Date: 15 December 2022
Our ref: 414770
Your ref: EN010106

NSIP Reference Name / Code: Sunnica Energy Farm, EN010106
Natural England's comments in respect of Sunnica Energy Farm Project, promoted by Sunnica Ltd

Examining authority's submission deadline 4, 16 December 2022

Drawing Title  
**FIGURE 10-14C  
 LANDSCAPE MASTERPLAN  
 SUNNICA EAST SITE B**

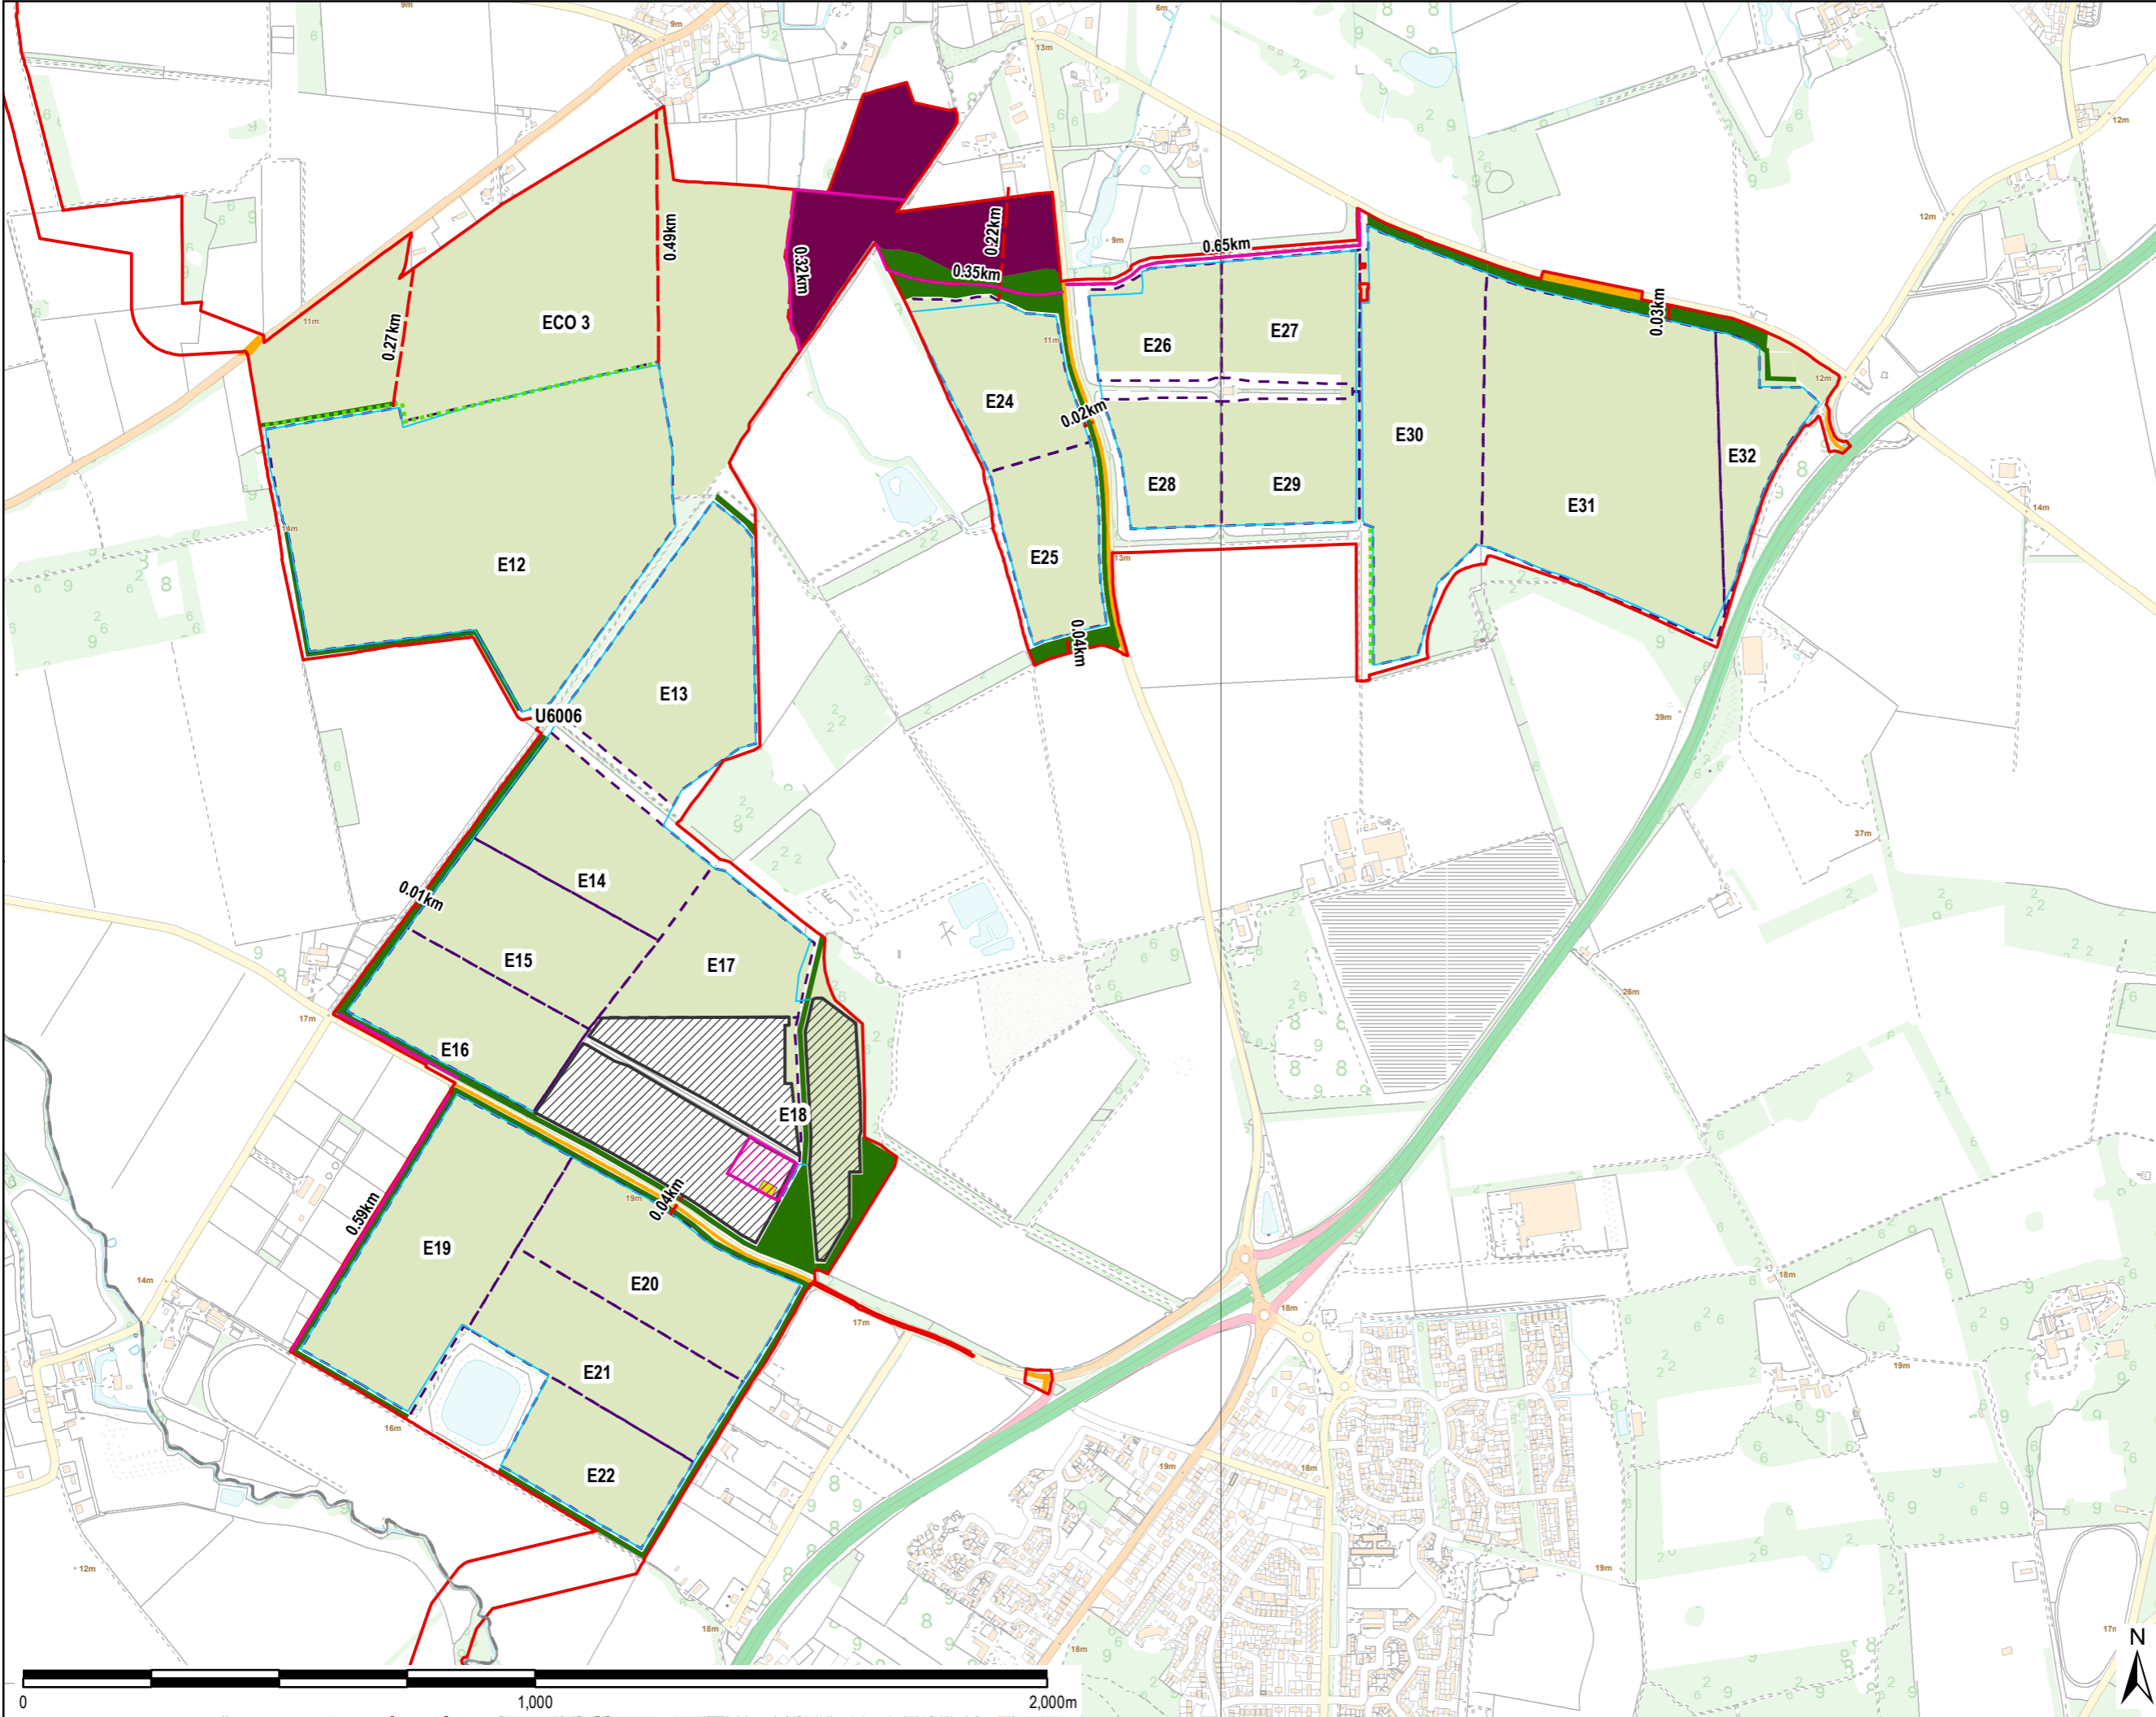
- 3.2. Additionally, there are four nesting plots proposed for ECO3 in Sunnica East Site B, but the area itself has not been marked as habitat created and managed for foraging stone curlew

- 3.3. Natural England requests clarification on the area of habitat that will be specifically created and managed for stone curlew, including whether this will include ECO3.

Drawing Number 60589004_ES_LSP_029B	Rev 0
---	-----------------

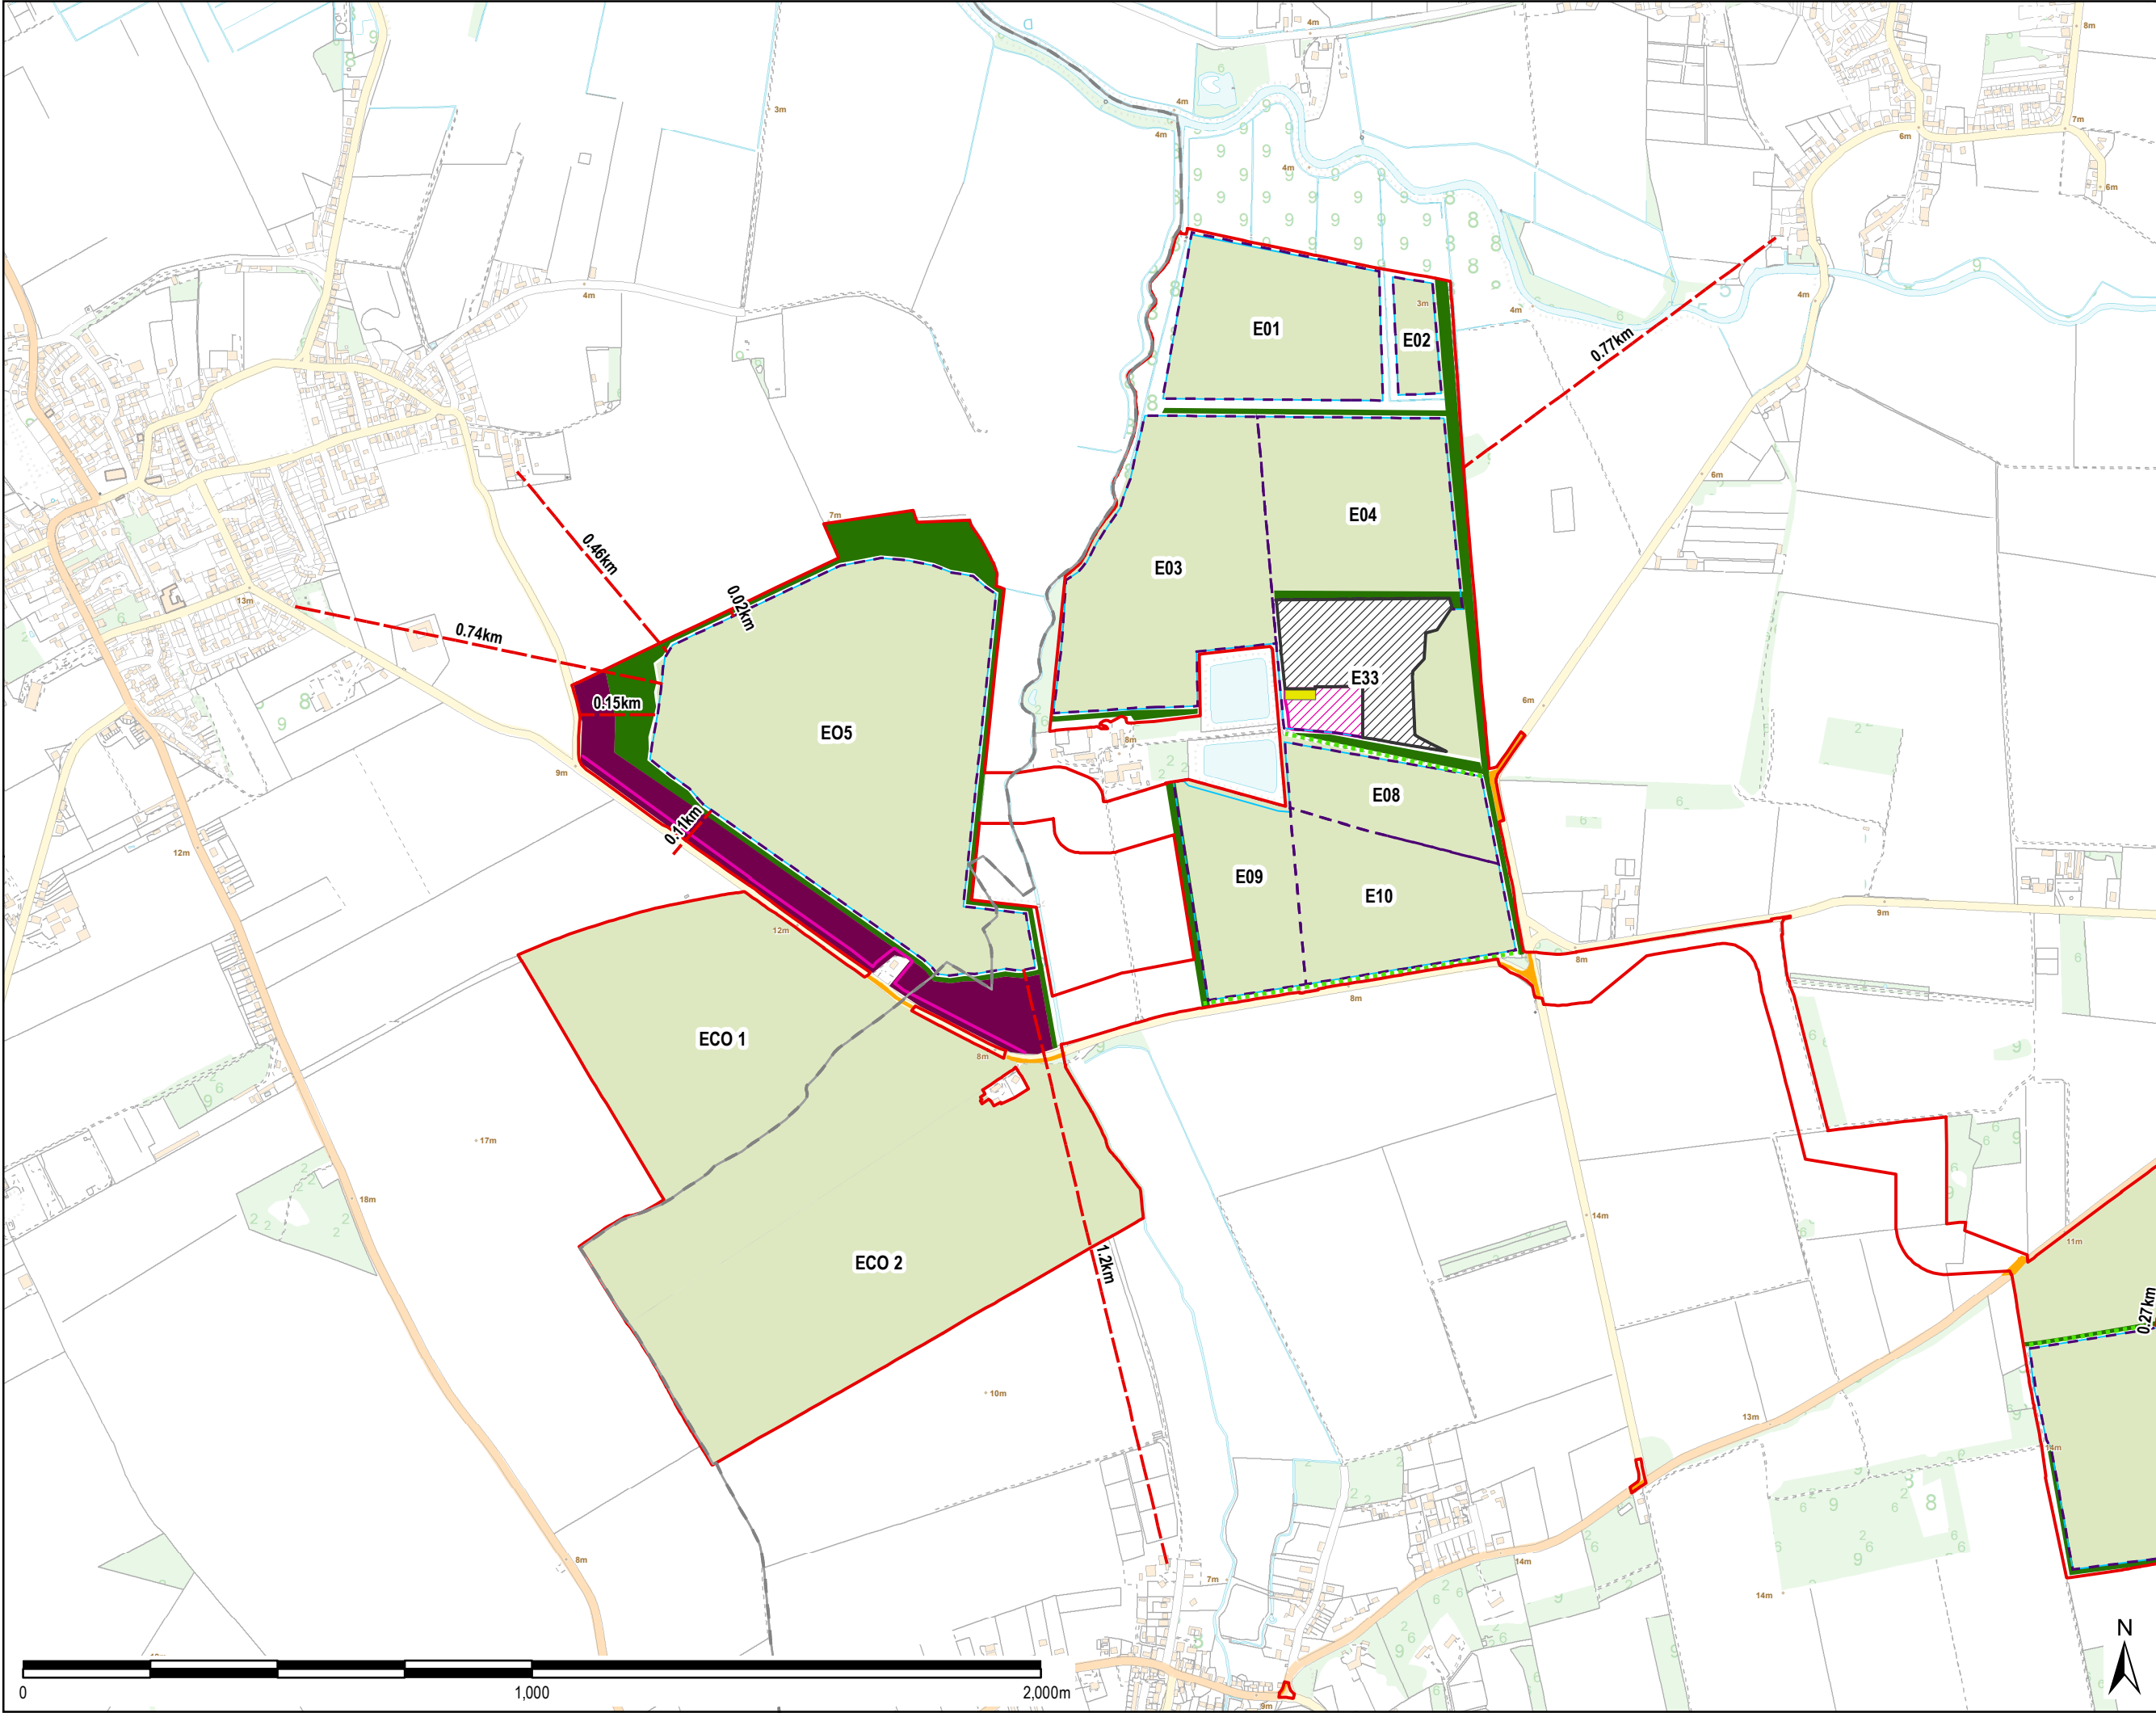
- 3.1. Natural England welcomes the Environmental Masterplan submitted at deadline 3 [REP3-022] and the clarification this provides for habitat proposals in the scheme. However, it appears that the only area being specifically created and managed for stone curlew are plots ECO1 and ECO2 in Sunnica East Site A. This does not seem to make up the whole 108ha discussed in other documents.

- 3.4. Natural England advises that, in addition to those characteristics shown on the masterplan, it would be useful to show any public rights of way in order to determine what impact, if any, these will have on the stone curlew offsetting habitat.
